Recommendation Report for Planning Permission for Works or Extension to a Dwelling

REF NO: AL/18/21/HH

LOCATION: Fairways
Fontwell Avenue
Eastergate
PO20 3RU

PROPOSAL: New roller door on garage, two storey side extension, rear white aluminium Bifold doors, garage to be increased in height, roof to have new gray tiles & first floor to have gray cladding.

Proposed FF Plan

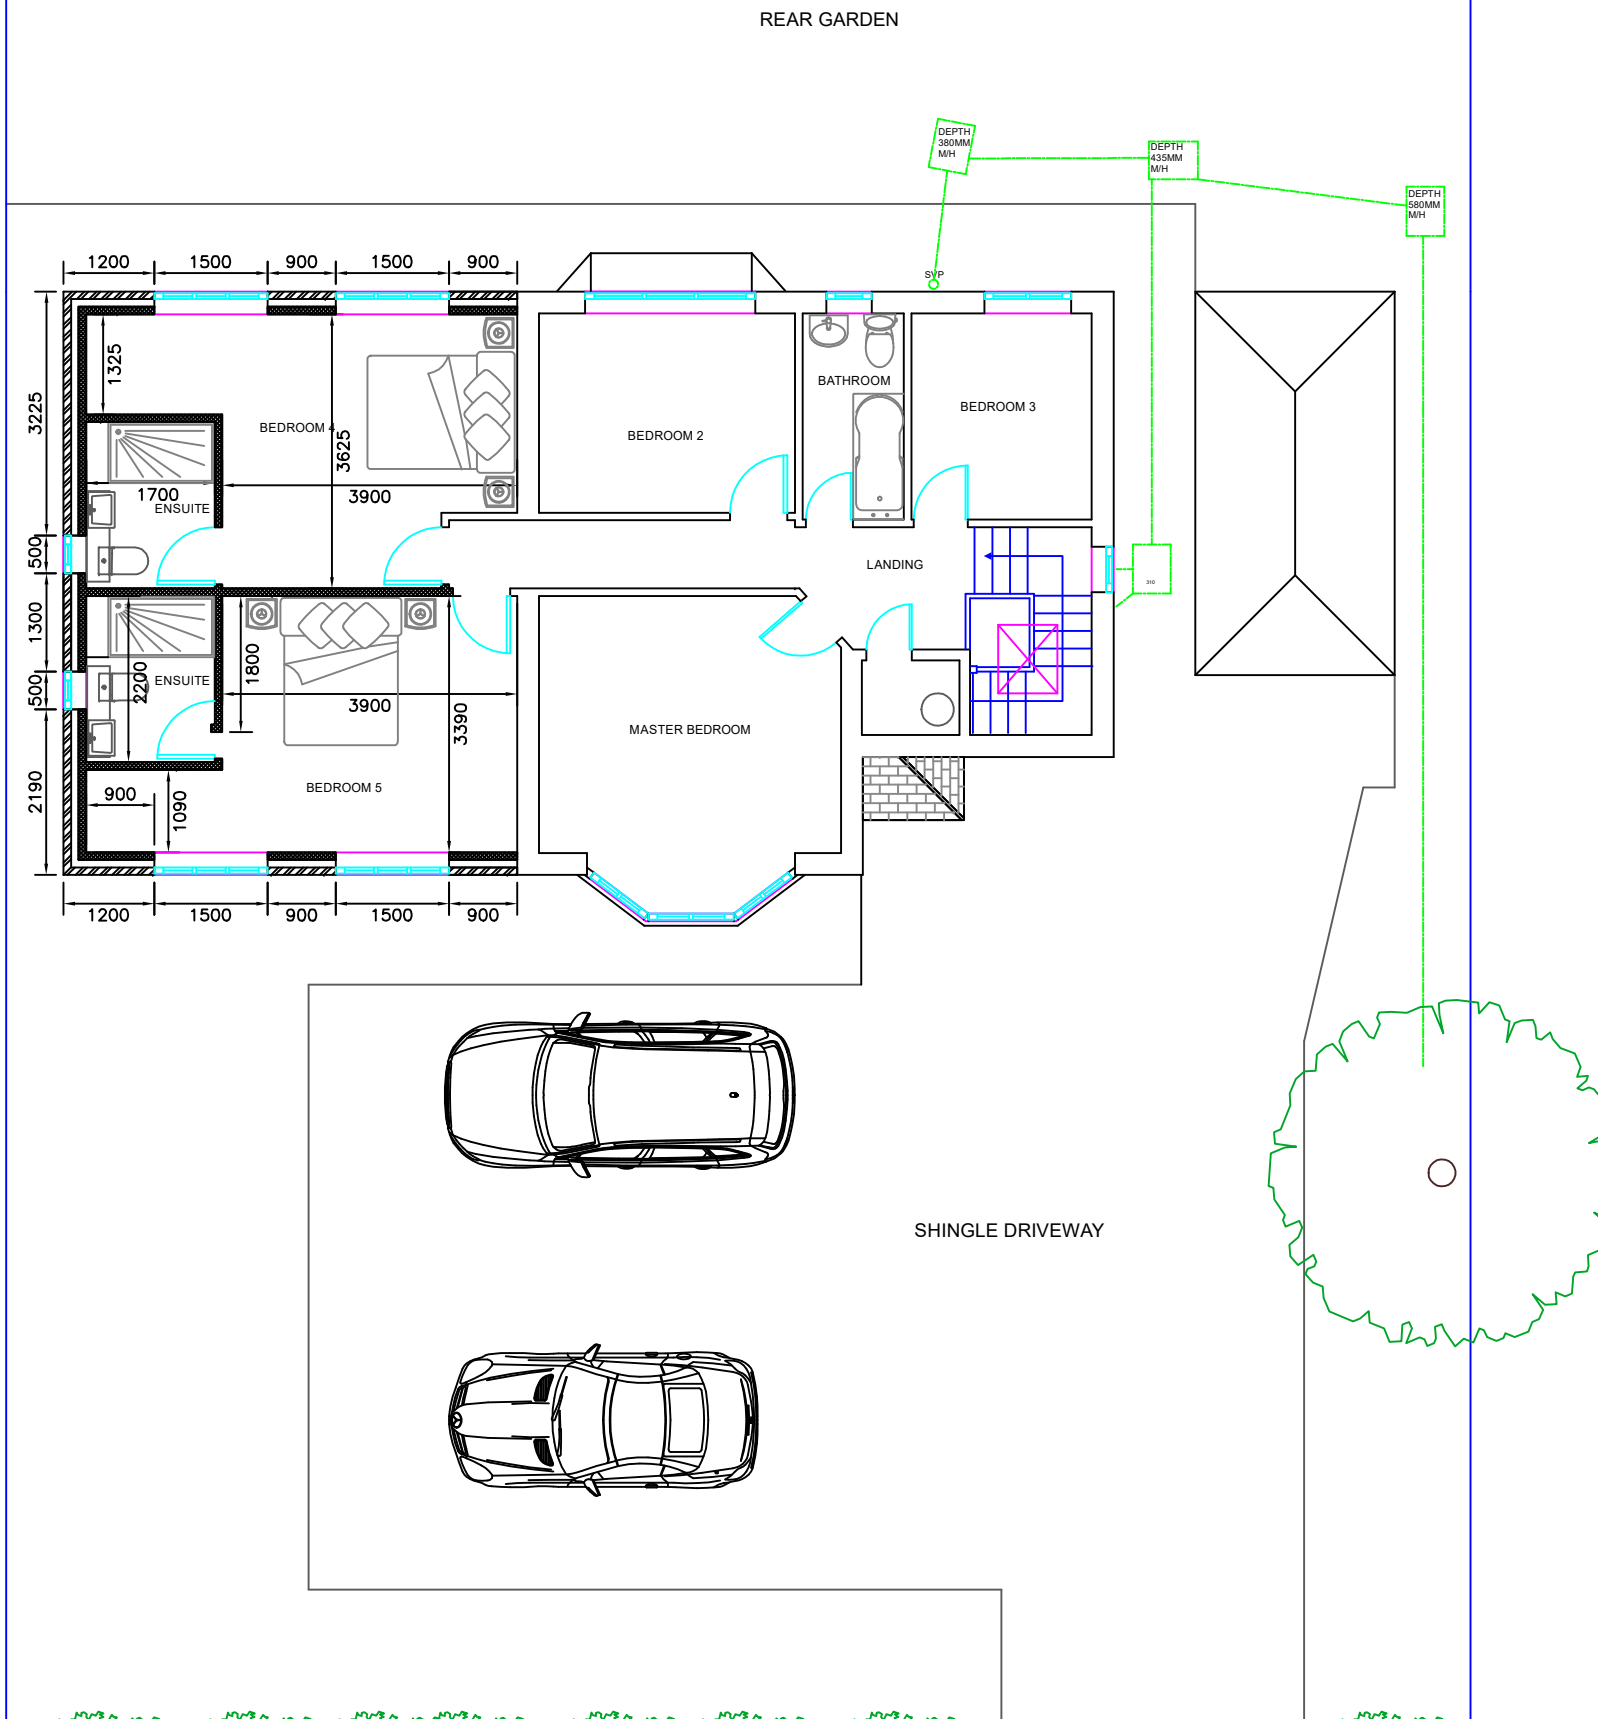
The property seeks to introduce a two storey side extension as well as other alterations to the property. The two storey aspect will have a maximum width of 6.6m at the western most point. The depth of the proposed side extension is 7.81m with a height of 7.9m to match that of the existing pitch height.

The separation distance between the proposed extension is considered sufficient to avoid any overbearing and overshadowing. This is due to the 0.7m gap to the boundary with a further 8m to the side elevation of the neighbouring dwellinghouse. The proposal does seek to have two windows on the side elevation at first floor. To avoid overlooking of the neighbouring property these windows have been conditioned to be obscure glazed and fixed shut to 1.7m, this is considered enough to mitigate any overlooking from the proposed development whilst allowing the function of the en-suites to not be impaired.

Reason: To comply with Section 91 of the Town and Country Planning Act 1990 (as amended).
- 2 The development hereby approved shall be carried out in accordance with the following approved plans ...
 - Location and Block Plan 01
 - Existing GF Plan No:01
 - Proposed GF Plan No:02
 - Existing FF Plan No:03
 - Proposed FF Plan No:04
 - Existing Roof Plan No:05
 - Proposed Roof Plan No:06
 - Existing Elevations No:07
 - Proposed Elevations No:08
Reason: For the avoidance of doubt and in the interests of amenity and the environment in accordance with policy D DM1 of the Arun Local Plan.
- 3 The window at or above first floor level in the East elevation of the building (shown on plan labelled Proposed FF Plan No:04) shall at all times be and remain obscurely glazed and fixed shut up to 1.7m from the finished floor level.

Proposed Elevations

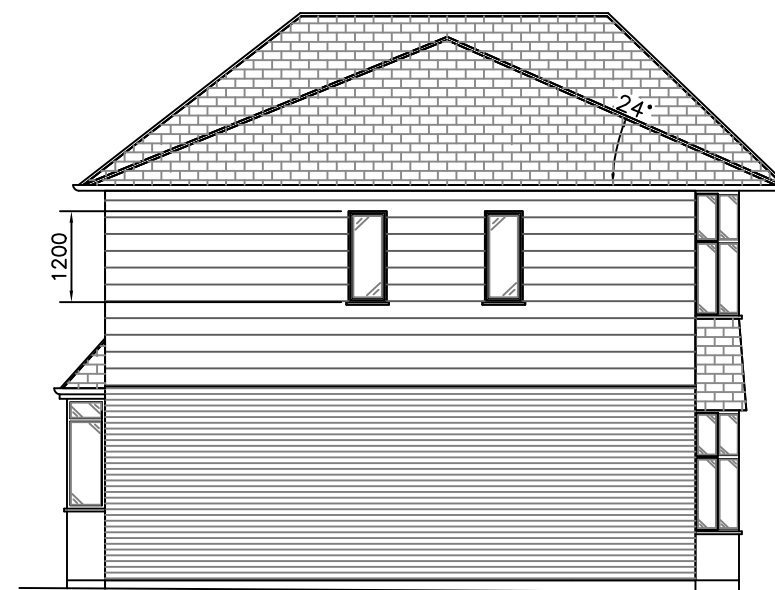
The proposed extension has an increase of 0.88m, which is minor in nature. Furthermore, the proposal extension aligns with the front and rear faces of the host dwelling which is also considered to contribute to the subservient and well integrated appearance of the proposed extension.

Whilst the proposal is not subservient to the dwelling it is not considered to cause reason for refusal. This is due to the location and use of materials that will match existing which seeks to ensure it appears well integrated and unobtrusive in appearance of the spatial pattern. Surrounding properties are mixed in design and style further allowing the proposal to appear well integrated with the surrounding street scene. Furthermore, there is some screening to the front of the property in the form of bushes and trees. There is also mature foliage between that of the main road and the private road that Fairways is located on, these screen the proposed development further.

The use of cladding is not dissimilar to others in the area.
